Recommendation Report for Planning Permission

REF NO: AL/73/13/

LOCATION: Existing Barn
Sack Lane Dairy
Sack Lane Lidsey

PROPOSAL: Conversion of barn into 1No. dwelling. Resubmission following AL/42/13.
Departure from the Development Plan.

PROJECT		Conversion of existing barn at Sack Lane Dairy, Lidsey	
SUBJECT		Site Plan and Location Plan	
SCALE	DATE	DRAWING No	Rev
1:200 & 1:1250	Mar 2013	2012 / 01 / 03	B
DRAWN	CHECKED

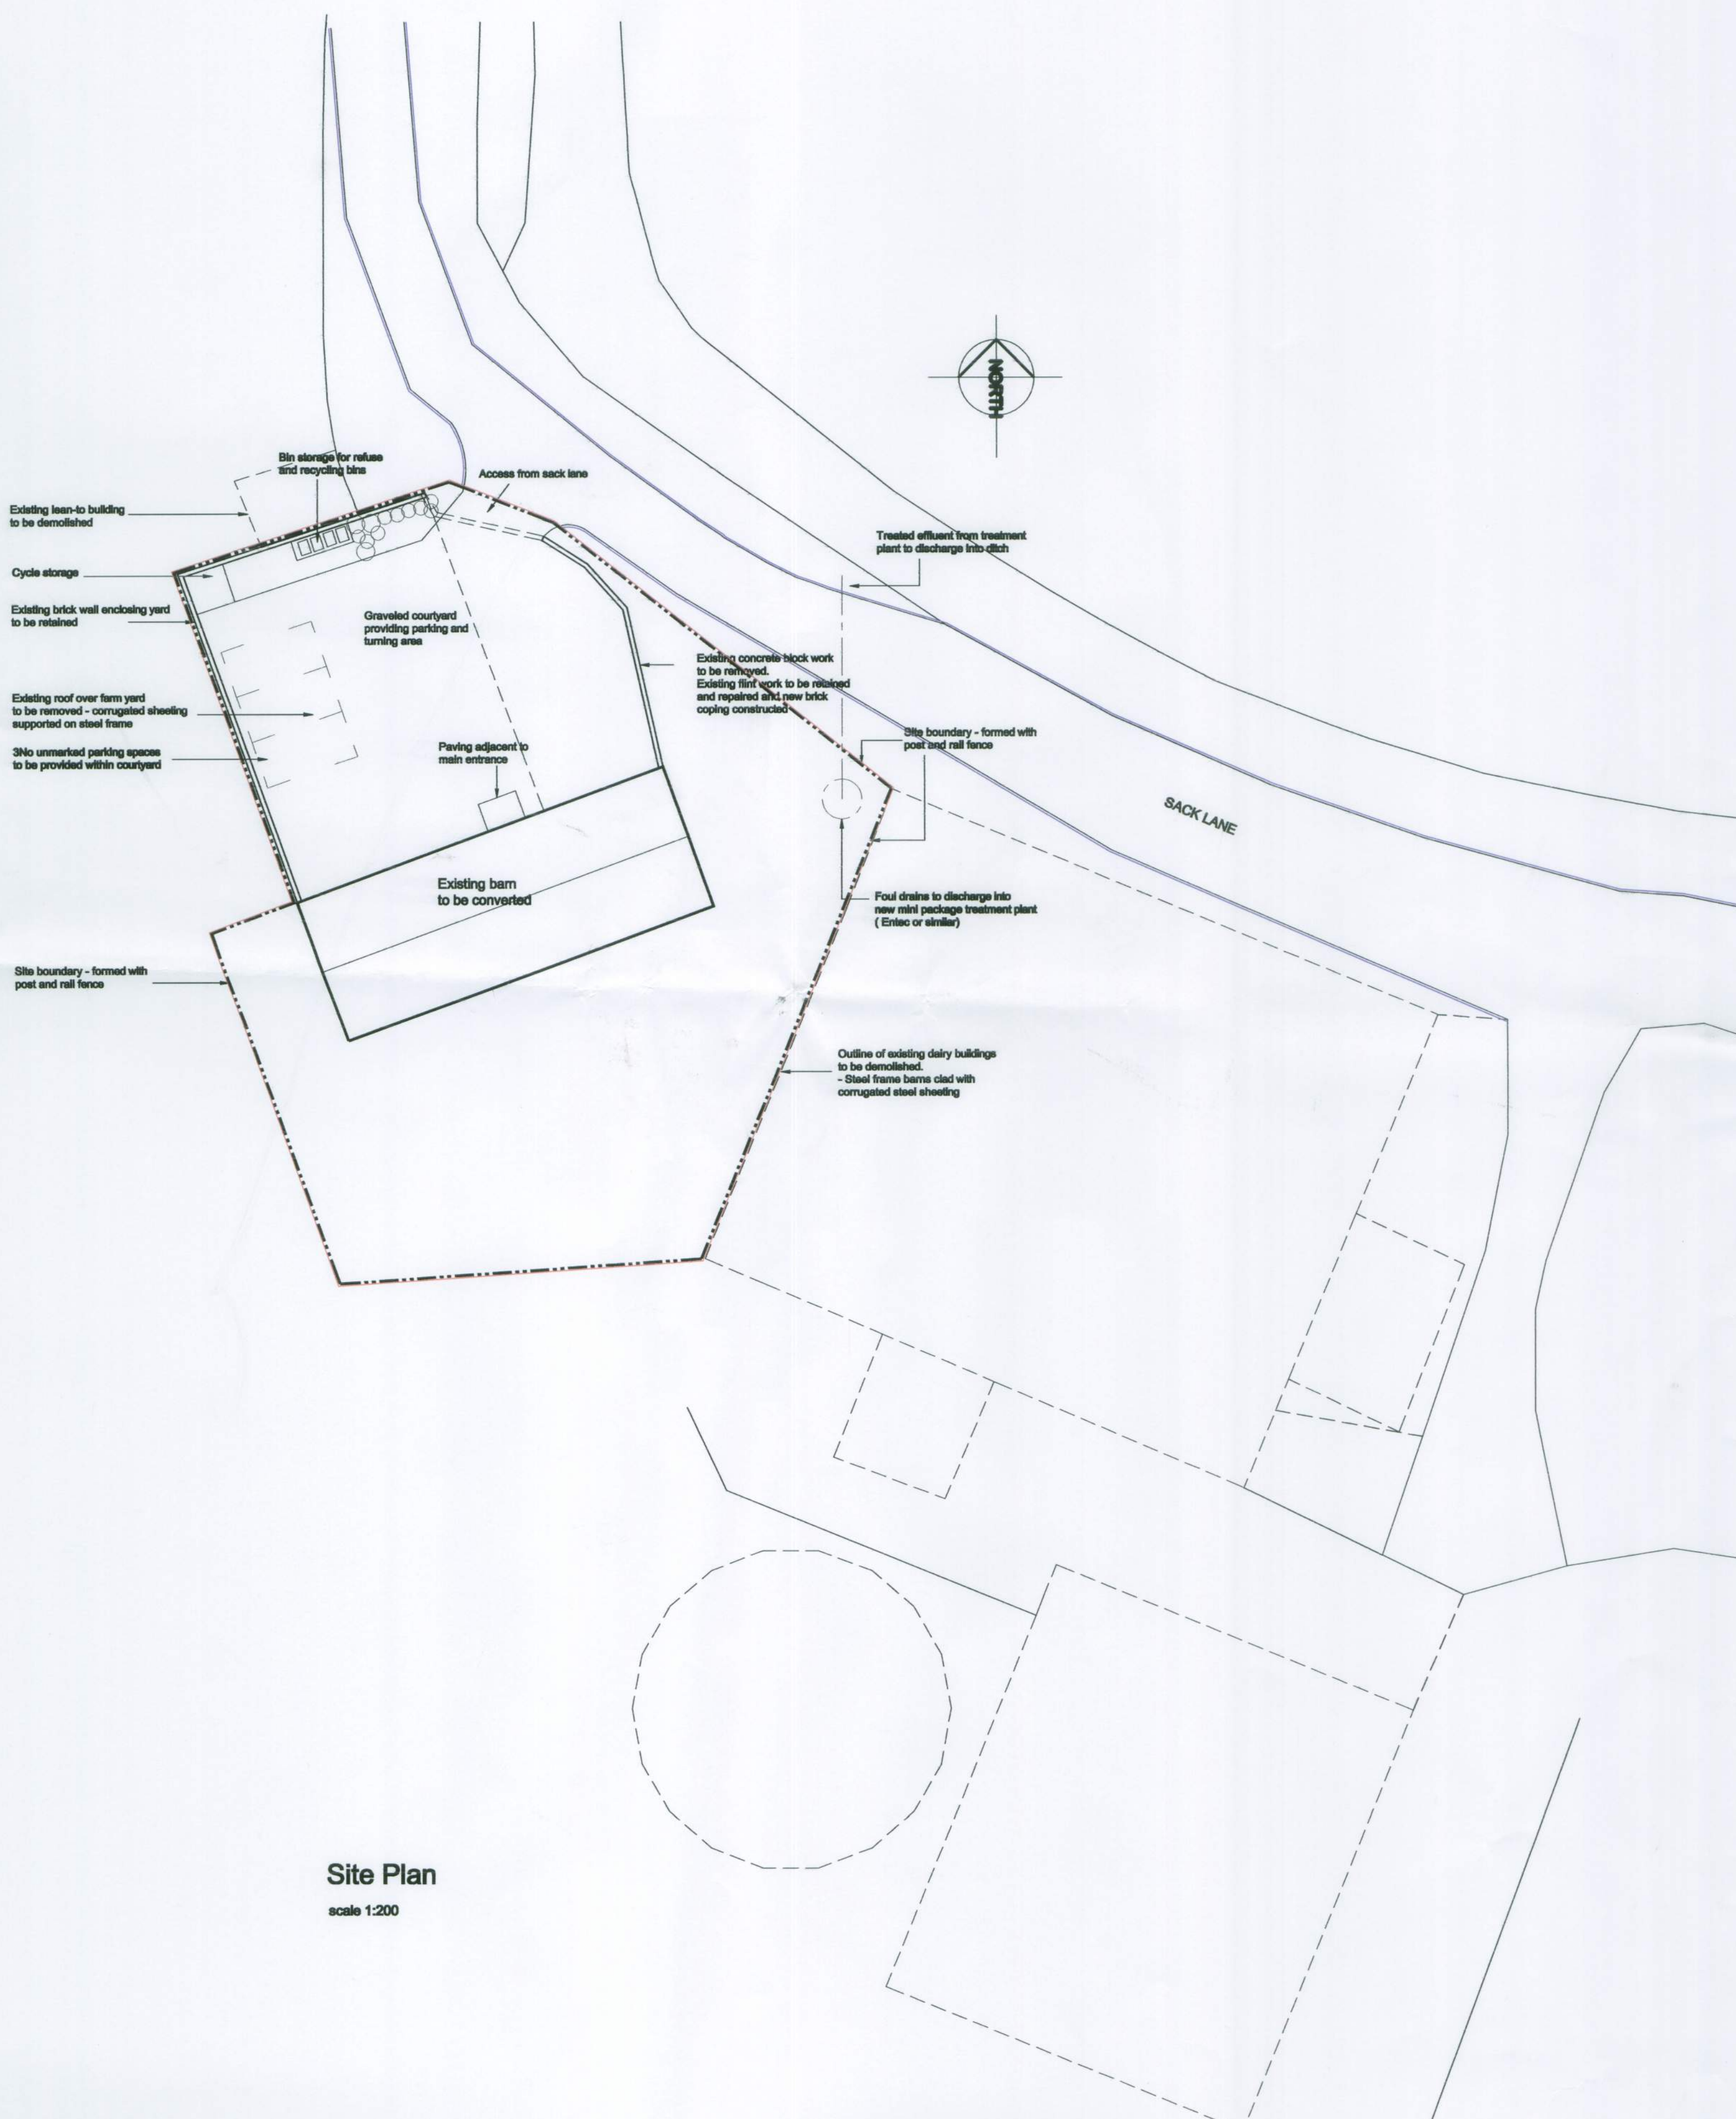
- 2 The proposed conversion to a residential dwelling would, by virtue of the large areas of new residential curtilage, be detrimental to the rural character of this site and the surrounding rural area in which it is located and the proposal is therefore contrary to policies DEV2(iii) & GEN3 of the Arun District Local Plan and policy H-DM3 of the emerging Local Plan.

REVISION			
PROJECT			
Proposed conversion of existing barn at Sack Lane Dairy, Lidsey.			
SUBJECT			
Proposed Plans and elevations			
SCALE	DATE	DRAWING No	Rev
1:100	Mar 2013	2012 / 01 / 02	B
DRAWN	CHECKED

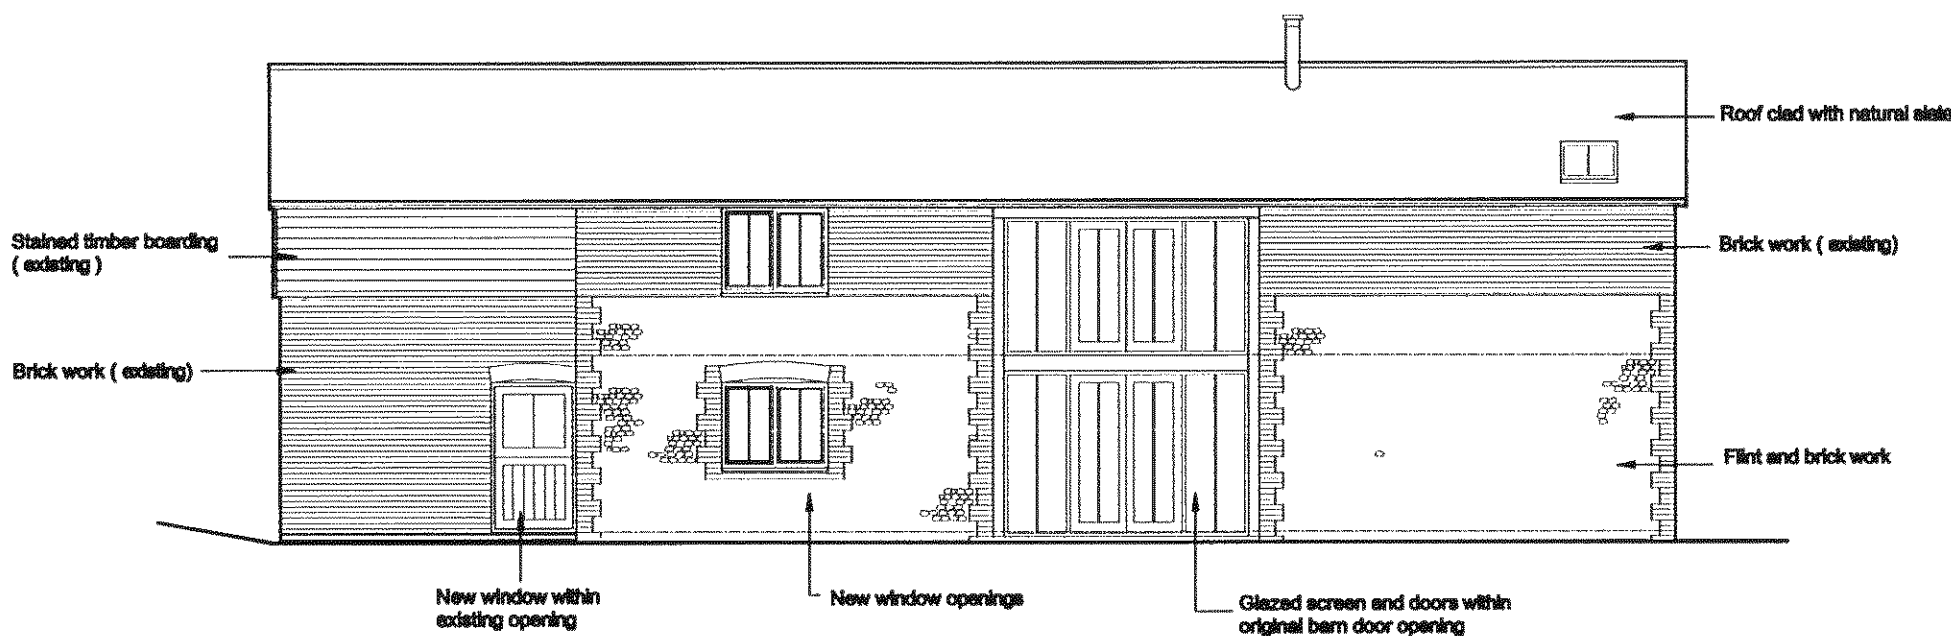
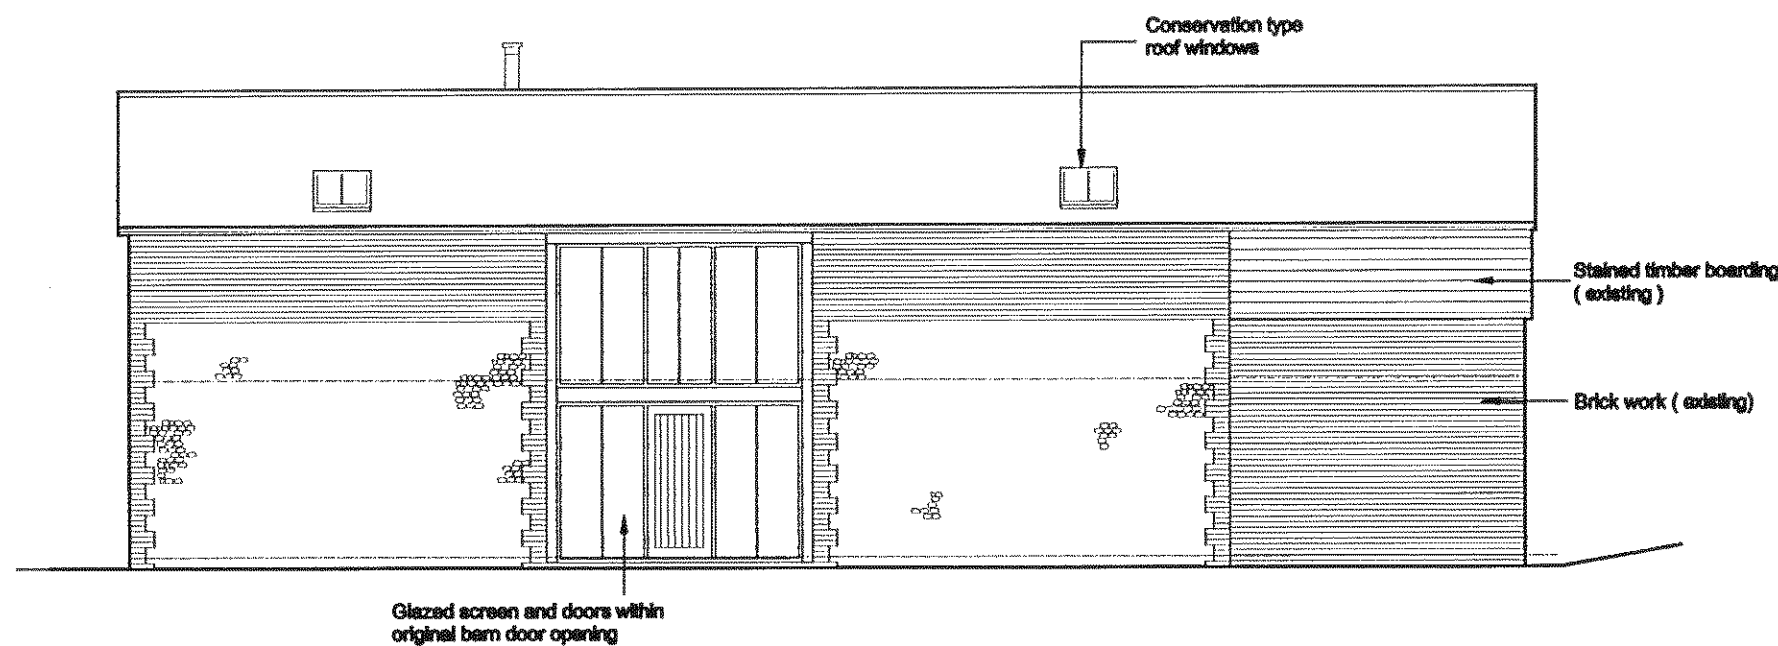
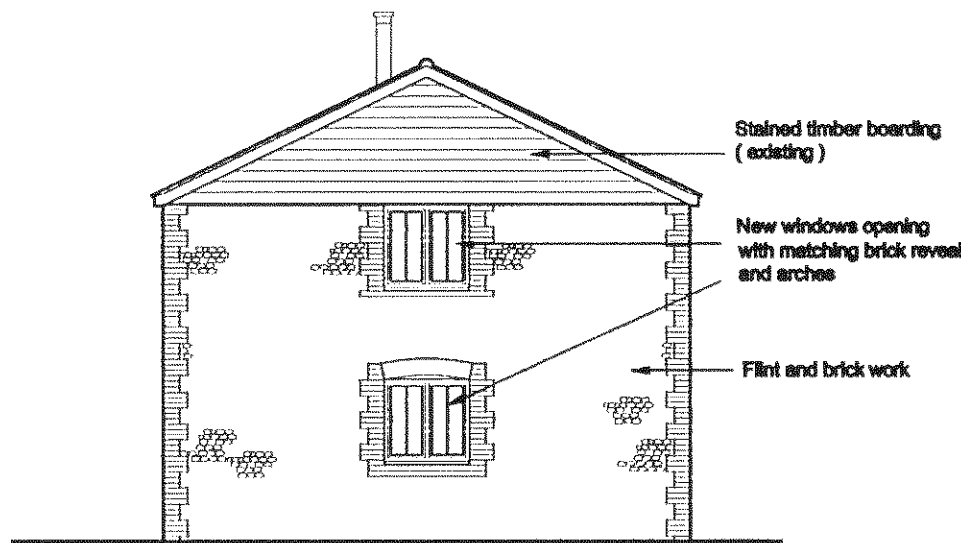
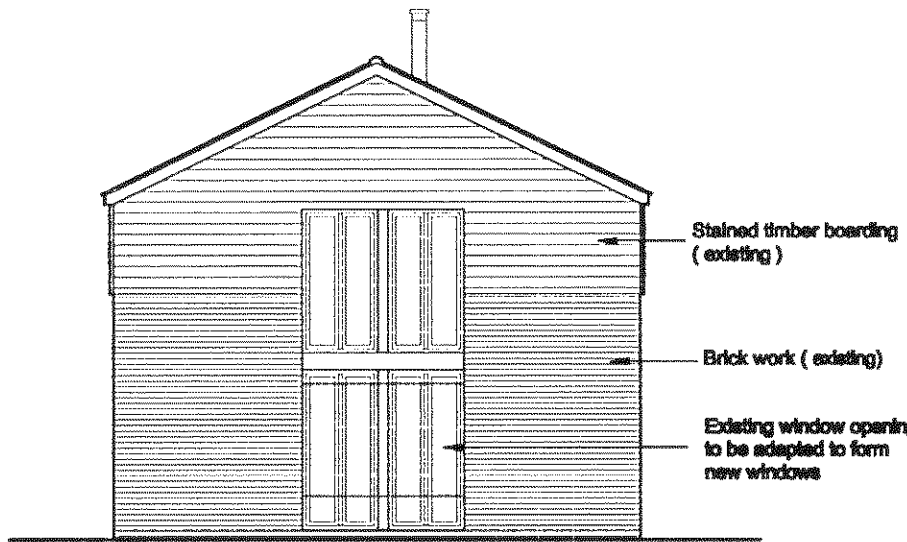
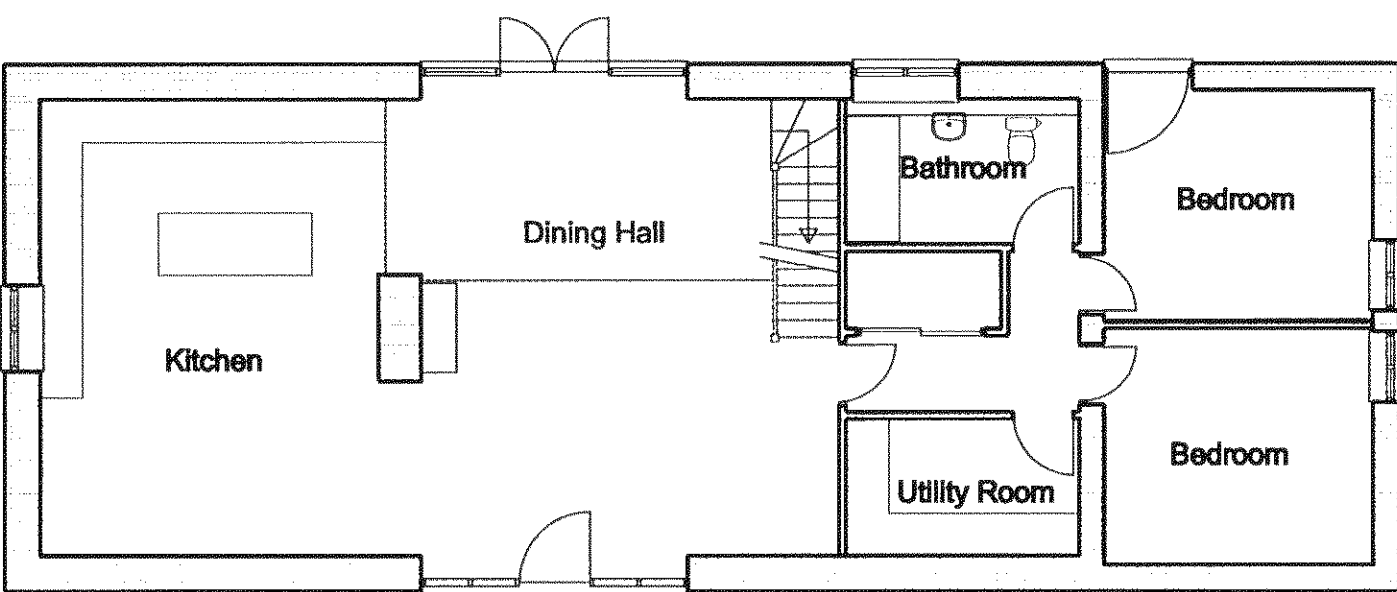
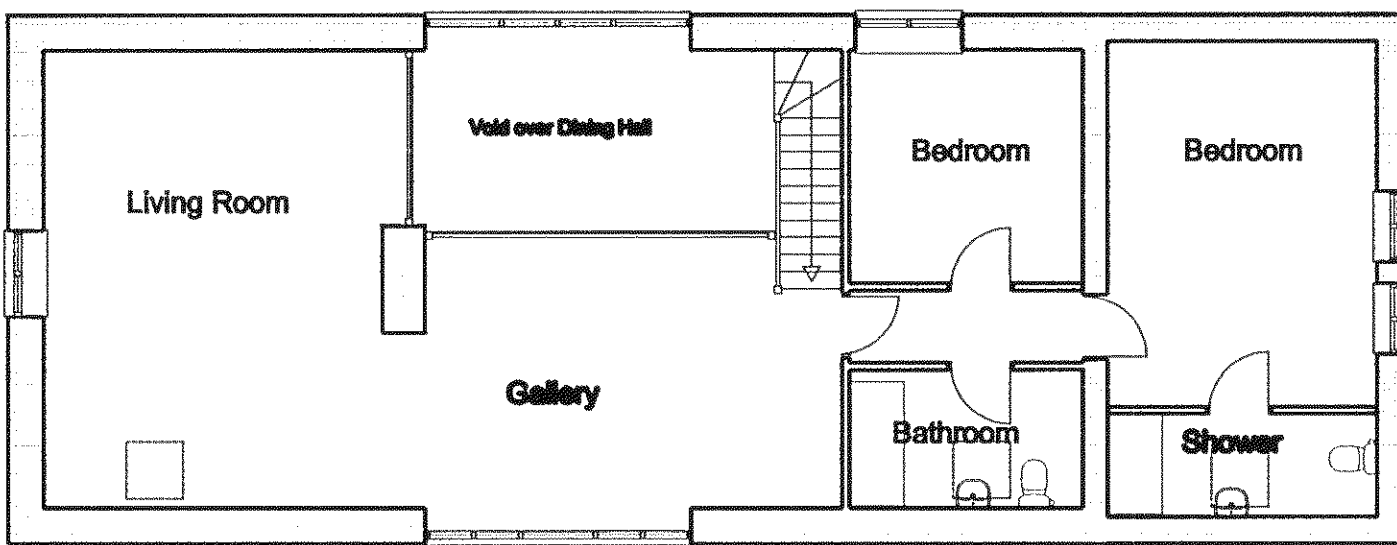
Historic Buildings Adviser - No Objection subject to amendments. Consider that the scheme has significantly improved on the last application but there remain a number of concerns which should be amended before support can be considered and which represent an accumulative level of harm to the agricultural character of the building and its setting. These have to do with: the staircase, windows, subdivision and the setting. Following receipt of amended plans, the following comment was received: "On the grounds that the barn is a non-designated heritage

asset this scheme is capable of support now. The only amendment we would recommend is changing the single door in the main opening to glass. A solid door here is not appropriate. Please condition all glazing and door details."
